Letter No. **B1/15484/2002**

Sub: Chennai Metropolitan Development Authority -  
Area Plans Unit - Planning Permission  
Construction of G+3 floors residential building  
with 4 dwelling units at Door No.1/1, Karunanidhi  
Salai, Kalakshetra Colony, T.S.No.27, Block  
No.49, Thiruvanniyur, Chennai - Remittance of  
charges - Reg.

SITE PLAN (SCALE 1:200)

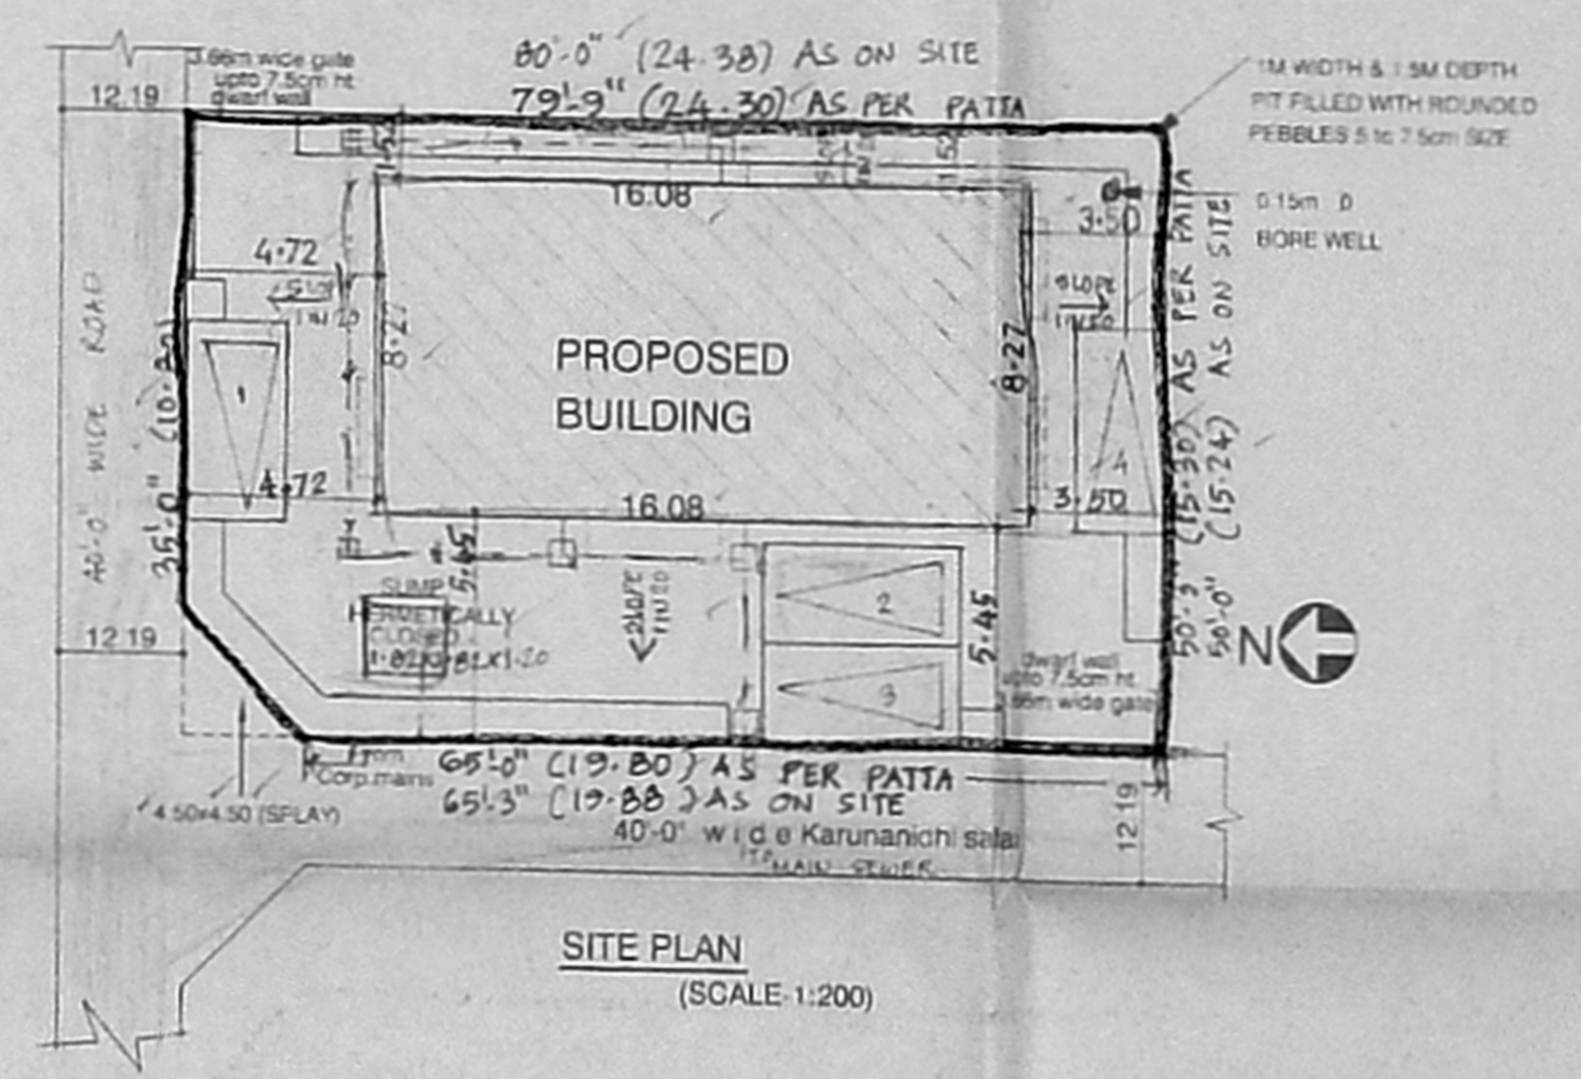
- e) i) Site dimensions as on site do not tally with the patta dimensions. Therefore, site plan is to be drawn showing both the dimensions as per patta and as on site with correct conversion into metric form distinguishing the difference by hatching and indicating the set back dimensions from the least dimension line, satisfying DC rules and tallying the building plans set back dimensions with that of least site dimensions.
- ii) Breaking dimension shown in Ground floor & typical floors do not tally on the western side with the overall dimension.
- iii) Cross sectional plan AA needs correction, since do not tally with the detailed floor plans.
- iv) Grading of 1 in 20 was not shown in the set back spaces towards the pebble trench.
- v) Lift machine room dimensions were not mentioned.
- vi) Sump capacity shall be restricted to 1000 L/D.U.
